From: lilleyarchitecture [REDACTED]
Sent: 16 January 2012 16:27
To: Katherine Rawlins
Subject: RE: P/51/11 Extension, alteration and new detached garage 7 Webb Close Pagham
 Dear Miss Rawlins

From: Katherine Rawlins [REDACTED]
Sent: 13 January 2012 14:34
To: lilleyarchitecture
Subject: RE: P/51/11 Extension, alteration and new detached garage 7 Webb Close Pagham

Thank you for the amended plans and proposals for No. 7 Webb Close.

North (front)

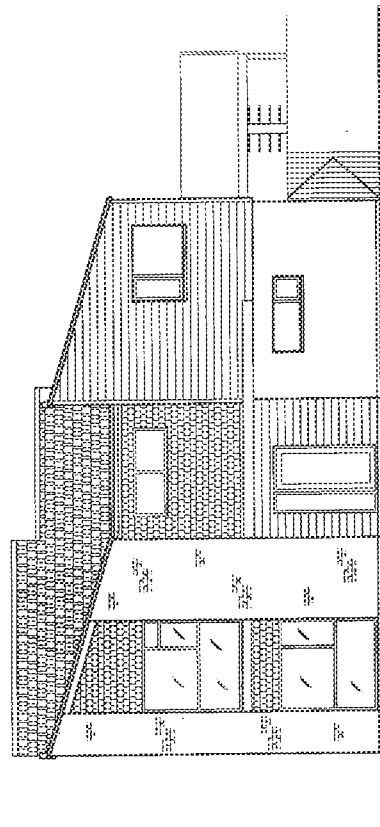
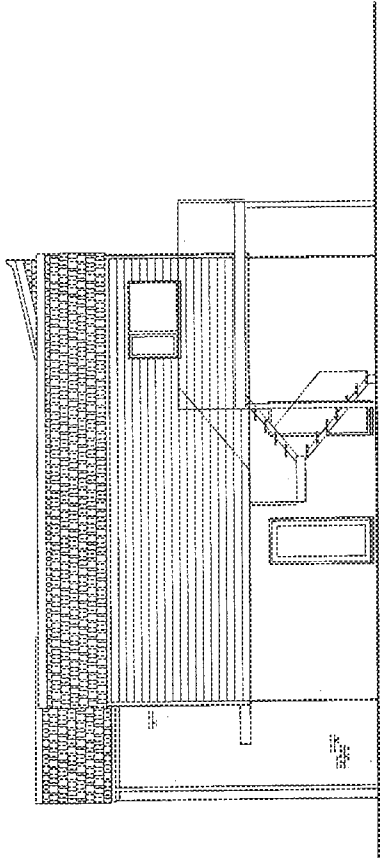
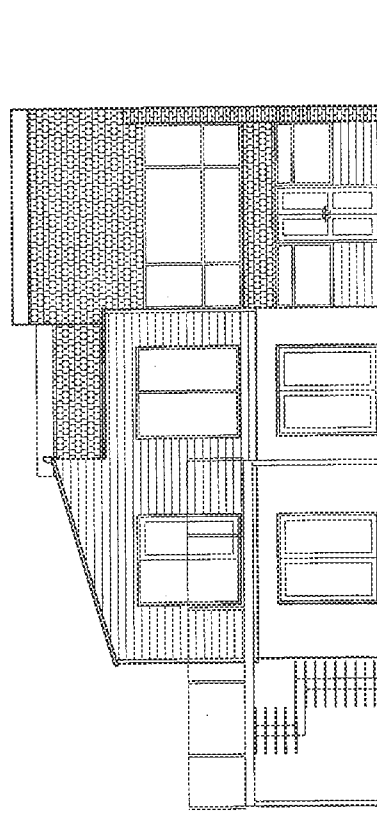
Having reviewed the plans, the addition of the mono pitch roof over the extension is considered to be an improved in design terms from the original scheme. This echoes the distinct character and appearance of this row of terraces.

However, I note the choice of materials of render and horizontal cladding, which does not reflect those of the main dwelling (yellow brick and tile hanging). Please could you explain the choice of materials?

The horizontal cladding is picked up from the horizontal cladding on the existing front and rear elevations (front door infill and rear infill panels on both ground and first floors). The intension is to replace these tired UPVC cladding panels with new more attractive horizontal cladding (either timber or fibre cement) that could be extended across the extension. This linking material (the horizontal cladding) then allows us to introduce the render on the ground floor of the extension as the two materials complement each other well. The property also benefits from being at the end of the terrace.

First floor

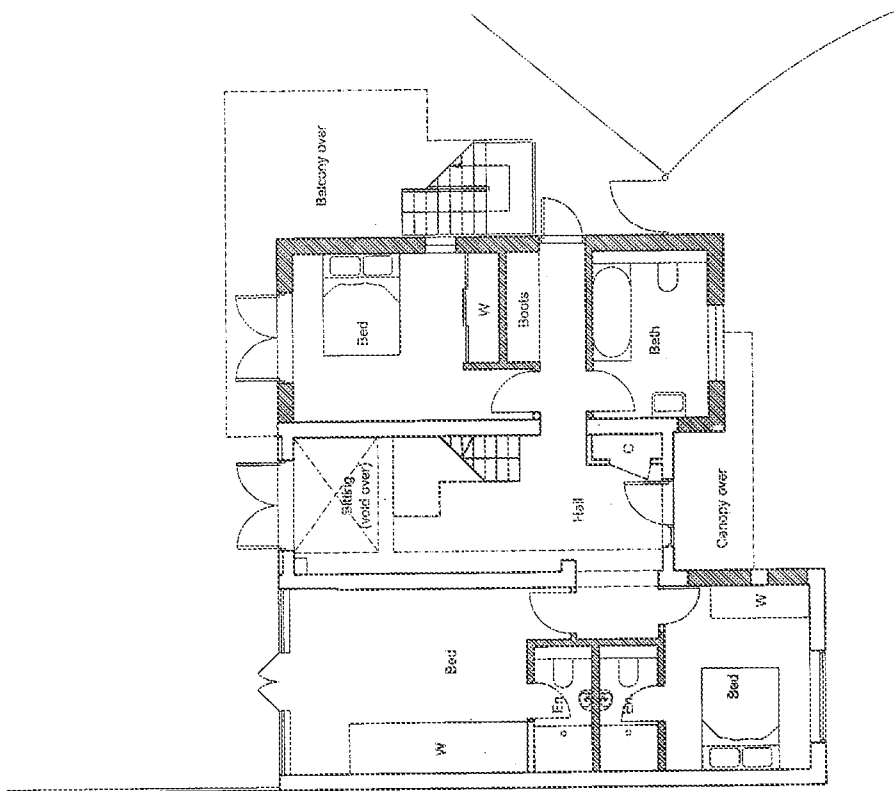
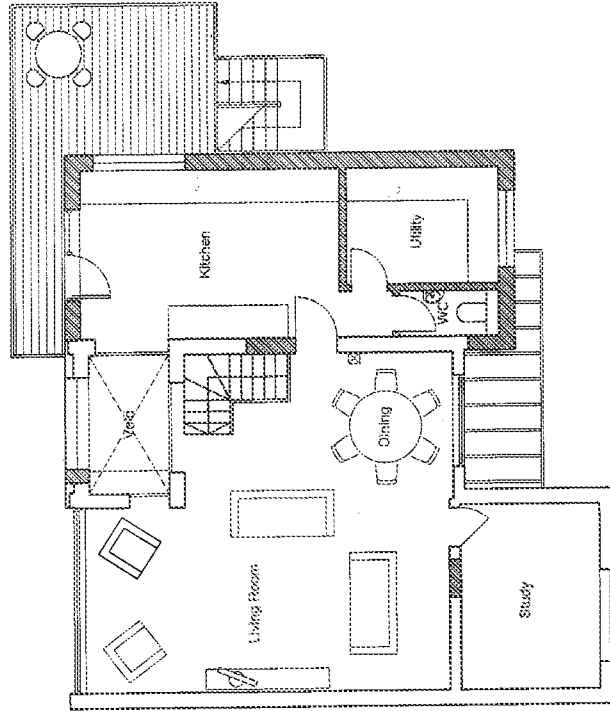
I note the omission of the detached garage and the re-positioning of the balcony to the side with rearward projection of 1 metre. I do have concerns regarding the rear projection of the balcony, even at this reduced depth, given the change in levels and the impact on the property at the rear, which is a bungalow. I would therefore suggest that the balcony is re-positioned entirely to the side and that a privacy screen is provided to prevent any overlooking.

I am disappointed regarding your comments on the terrace and feel there is a case for supporting my revised proposals especially considering the current external stairs provides a similar outlook anyway. However I will discuss re-positioning the terrace entirely to the side with my client. Before I do so can you clarify that if the terrace is to the side there will be no need for any privacy screen as there will be no greater incidence (in fact a reduction due to the loss of the original external stairs) of overlooking than experienced from the original dwelling.
